**WELWYN HATFIELD BOROUGH COUNCIL  
EXECUTIVE DIRECTOR - PLANNING, PUBLIC PROTECTION AND GOVERNANCE**

**Application No:** 6/2022/1398/HOUSE  
**Location:** 10 Dragon Road Hatfield AL10 9LX  
**Proposal:** Conversion of loft into habitable space with insertion of roof lights and rear dormers  
**Officer:** Ms Ashley Ransome

**Recommendation:** Granted

Drq.No: AT1072-04

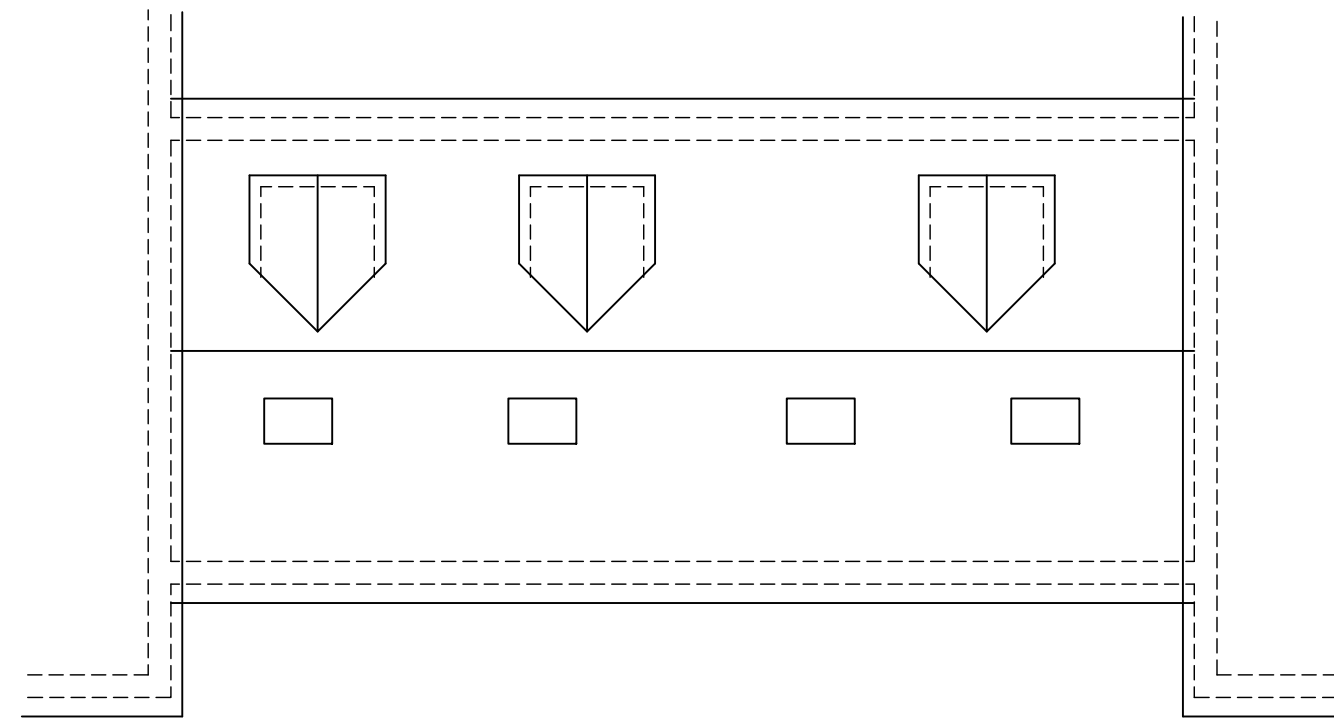
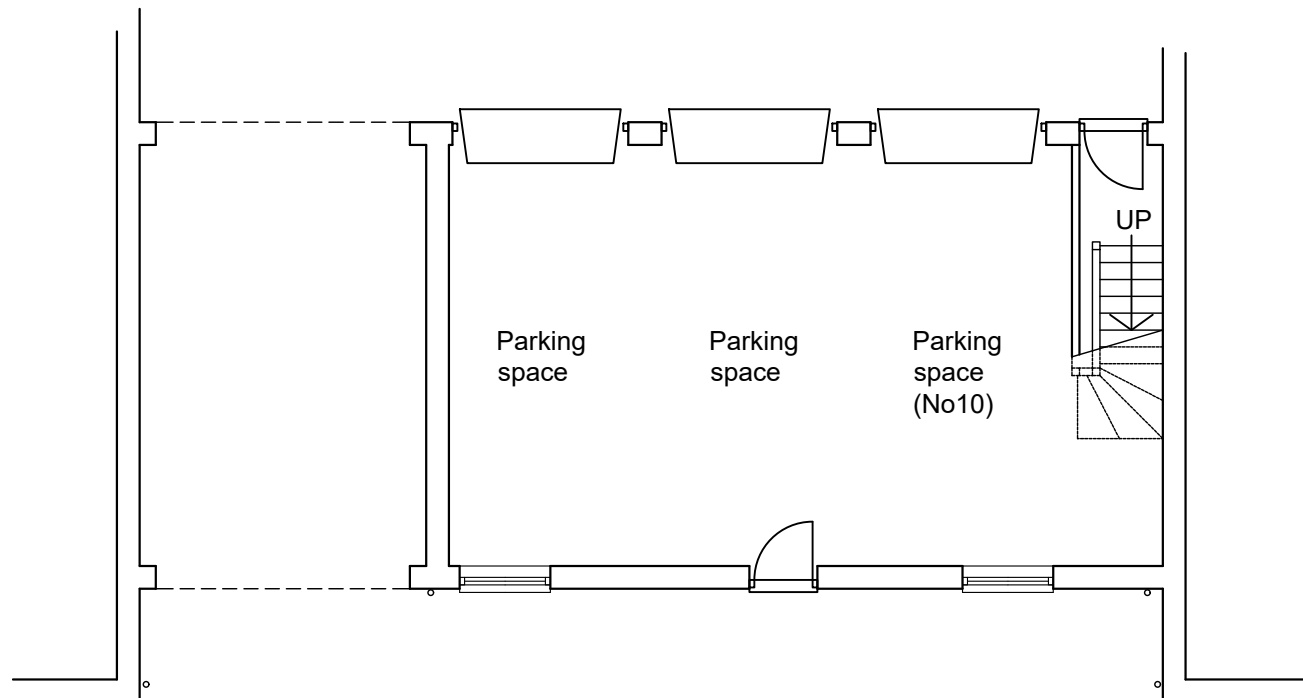
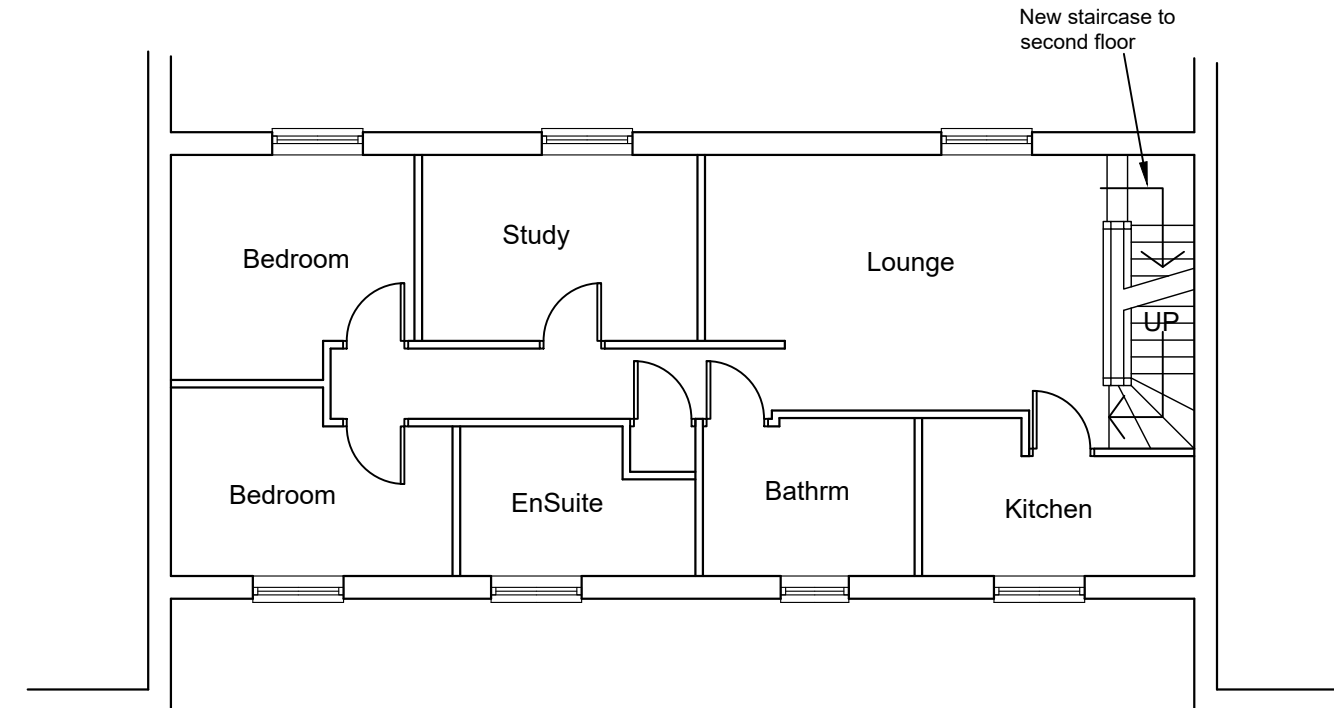
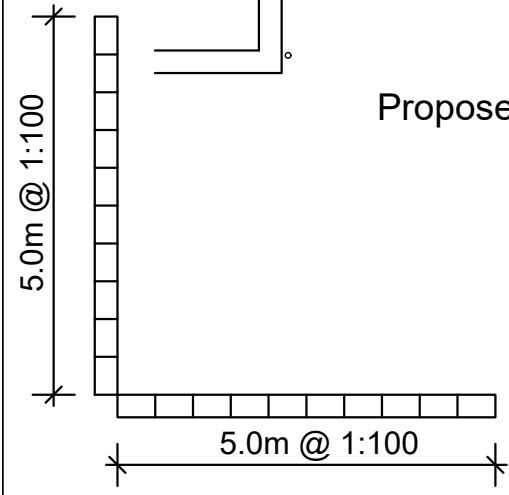
The proposal would increase the number of bedrooms from three to four (the study could be used as a bedroom so it is included within the total). The Council's car parking guidance for a dwelling with

four or more bedrooms in this location is three spaces per dwelling. The site appears to have one off-street parking space to the rear of the site. Whilst this is an under provision of off-street parking, the streets surrounding are for resident parking permit only. The site is also located within walking distance (10-15 minutes) to the amenities along Goldsmith Way and less than a 5 minute walk away from bus stops which provide access to amenities that are further afield such as Hatfield Town Centre which is approximately a 15 minute bus ride away. The site is therefore considered to be sustainably located and thus there may not be the requirement for three vehicles. It is therefore considered that sufficient parking is provided at this site and is in accordance with Policy M14 of the Welwyn Hatfield District Plan, Policy SADM12 of the Welwyn Hatfield Draft Local Plan 2016 and the Welwyn Hatfield Supplementary Parking Guidance 2005.

Drg.No: AT1072-05

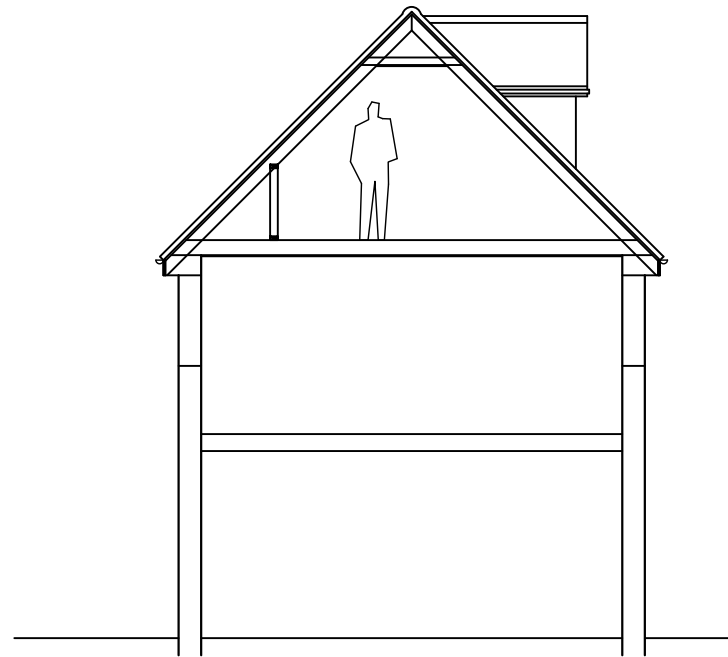
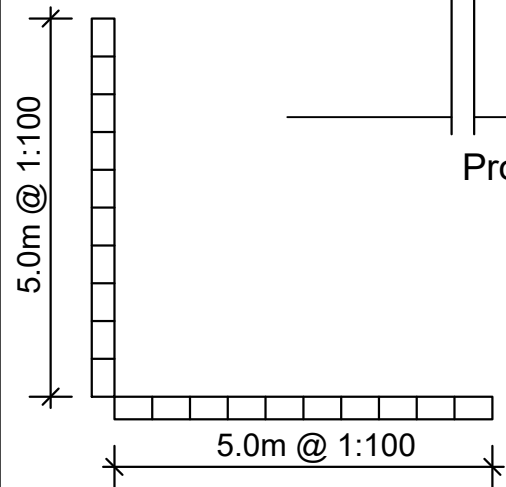
The Council's Supplementary Design Guidance states at paragraph 5.2 vi that 'dormer windows should be contained within the roof slope, be subservient to the roof of the property and be in proportion to the existing fenestration of the property. They must not extend above the ridge height of the existing dwelling and the dormer cheeks should be at least 1 metre from the flank wall of the property or of the party wall with the adjoining property.'

It is considered that the proposed rear dormers are of limited extent and modest proportions that comply with the above. The proposed front rooflights are also considered acceptable.
